Please ask for: Mrs D Johnson
Email: daun.johnson@arun.gov.uk
Telephone: 01903 737762
Our Ref: LU/58/22/A
Your Ref:
Date: 4th March 2022

Town & Country Planning (Control of Advertisement) (England) Regulations 2007 (as amended)

Application for Consent to Display an Advertisement(s)

Development: 1 No internally illuminated fascia sign and 2 No poster signs on front elevation.
Location: 18 Beach Road Littlehampton BN17 5HT

PROPOSED FRONT ELEVATION
Scale: 1/100

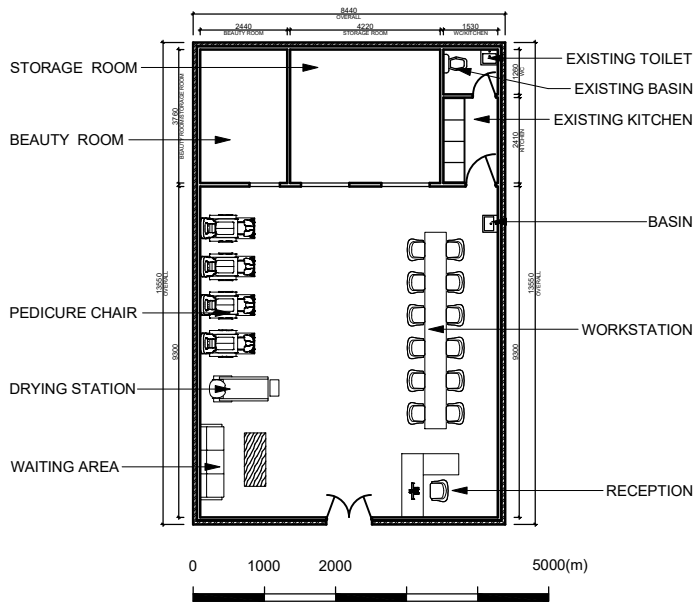
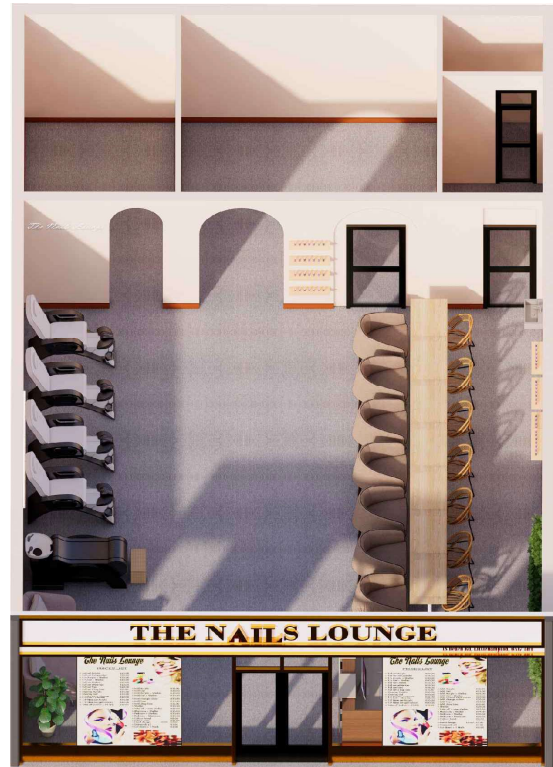
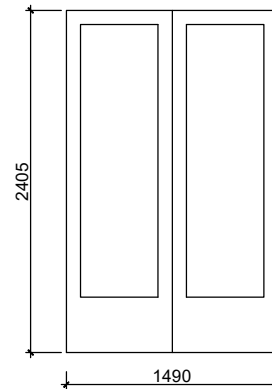
The application form indicates 2 No poster signs on the front elevation. Please show the position of these poster signs on the proposed front elevation.
